A/158/18/PL

Variation of condition 1 imposed under A/8/18/PL relating to the substitution of approved plan drawings NO ADC 962 04 rev A & 13 rev B for drawings No ADC 962 20 & 21 (ground & first floor plans & roof plan). This application affects the character & appearance of the Angmering Conservation Area.

Land Rear Of 1 To 6 The Cottrells Angmering BN16 4AF

Ground Floor Plan @ 1:100

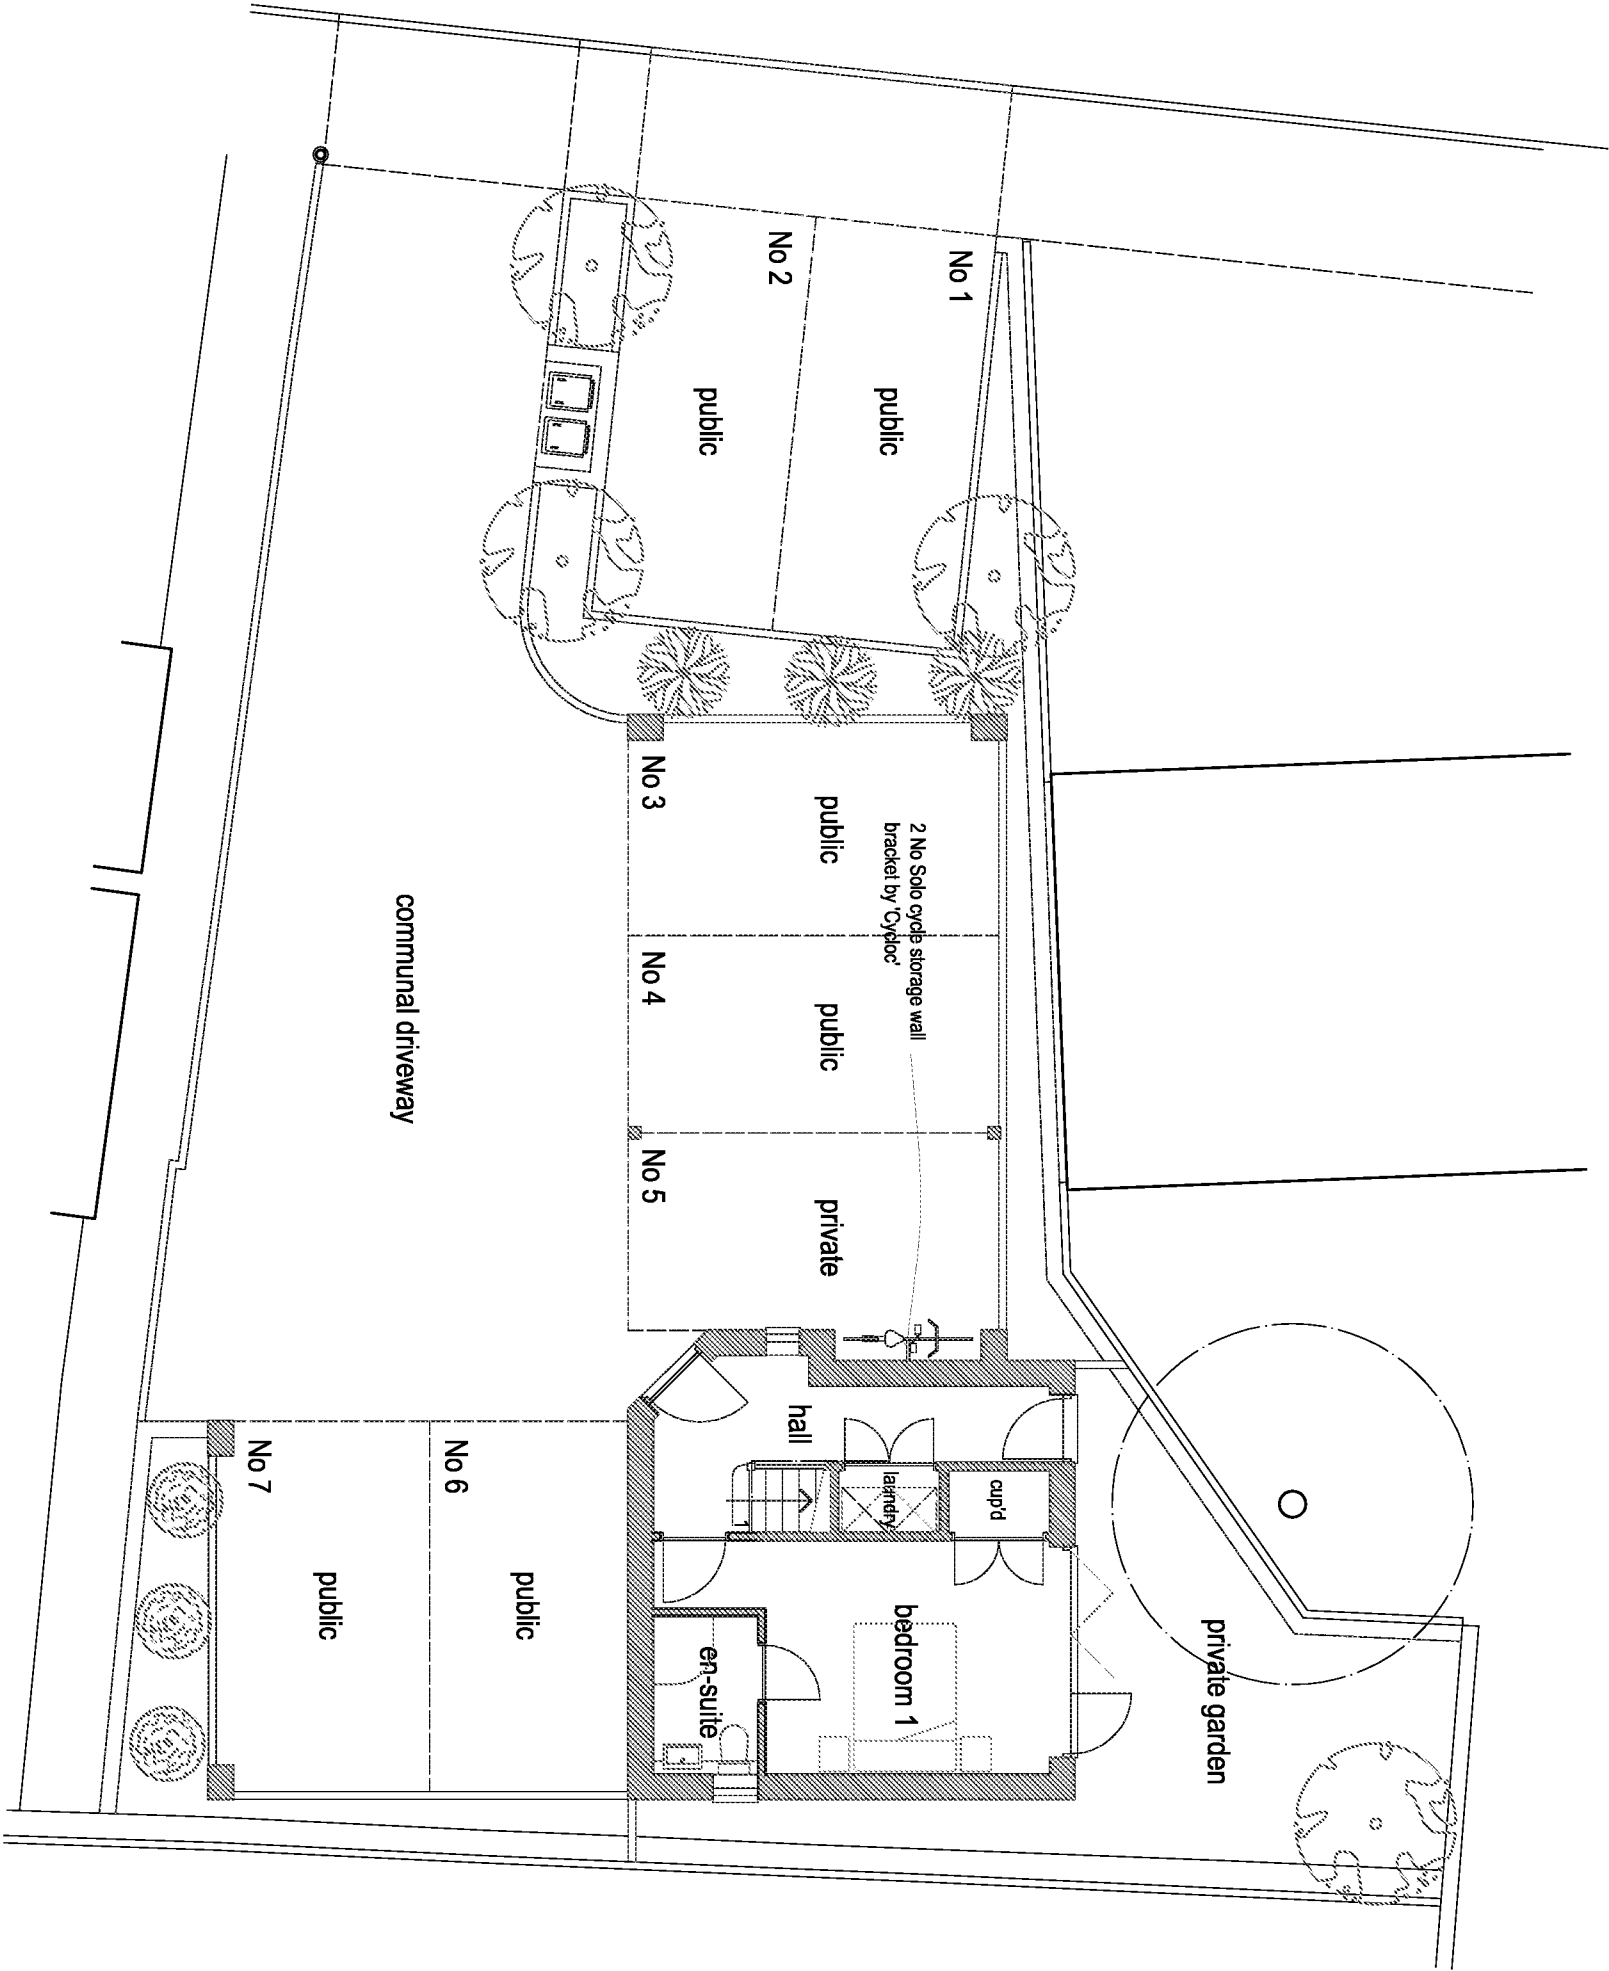
1. Planning permission was initially granted for a 2 bedroom flat above with a garden/cycle/refuse store downstairs A/105/16/PL. The downstairs was then altered to a kitchen/diner A/173/16/PL and now it has been changed to what has been built ie a bedroom with ensuite making this a 3 bedroom property.

Arun have already turned down a planning application for this to be a 3 bedroom property as it would over develop the site and create additional parking, which is already oversubscribed. The planning consent is for a 2 bedroom property with a kitchen/diner downstairs, thereby limiting the number of bedrooms and thus people occupying the property and the number of cars they are likely to have. The limitations of this site have not altered in any way since the original planning permission was granted.

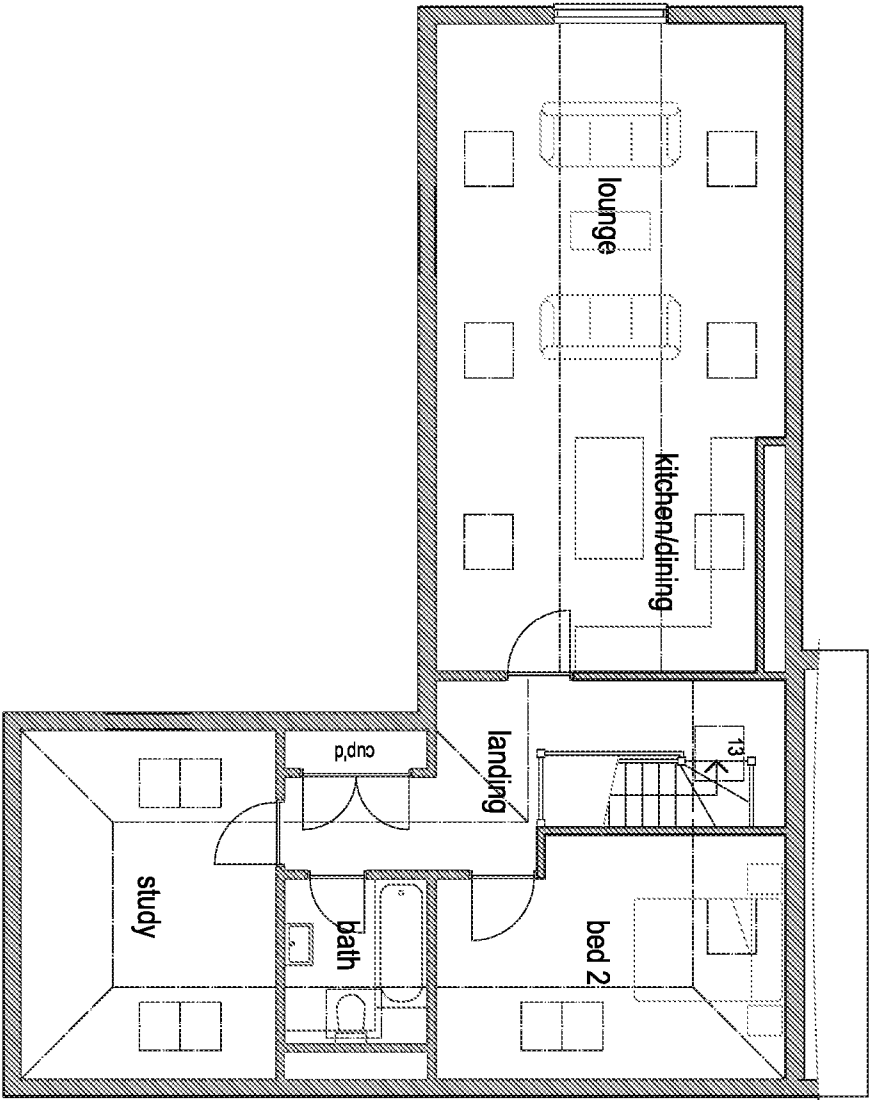
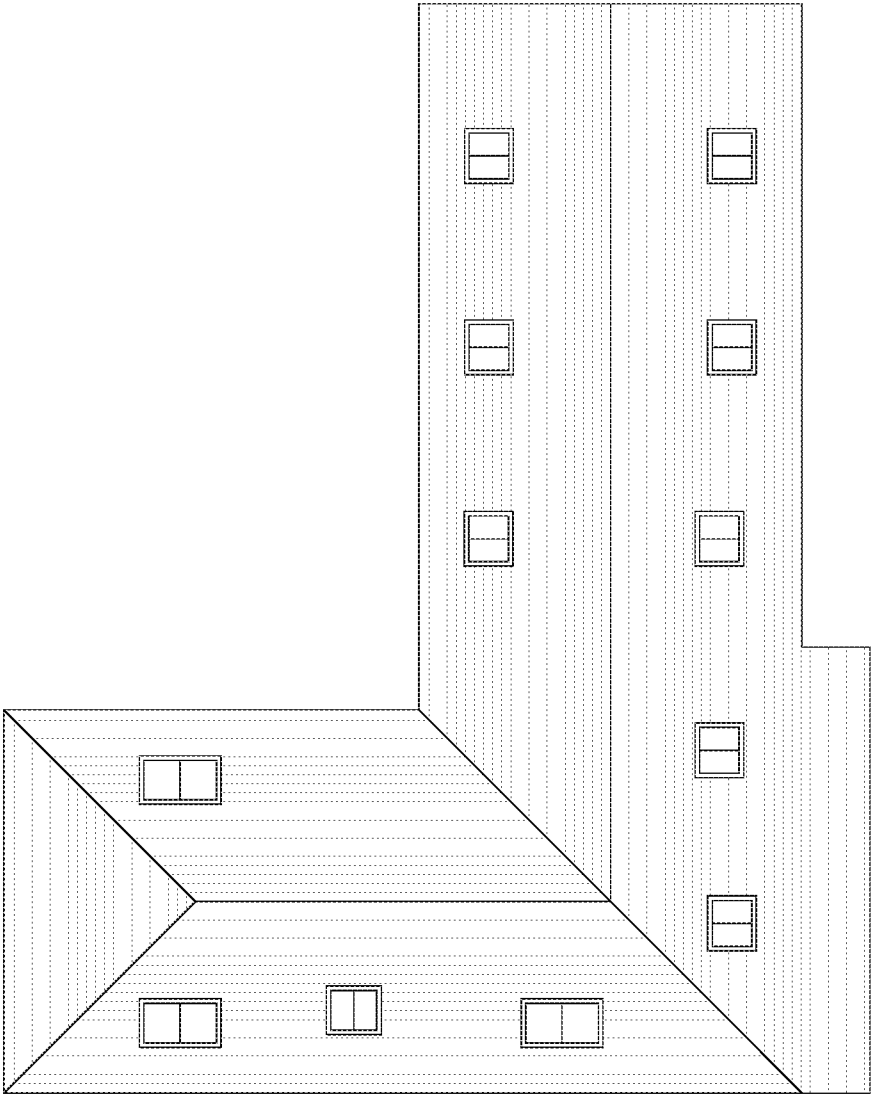
2. The windows as per the approved planning should be emergency roof lights positioned higher up the roof to ensure privacy particularly for the back bedrooms of nos 4 and 5 The Cottrells. The windows installed do not give this privacy.
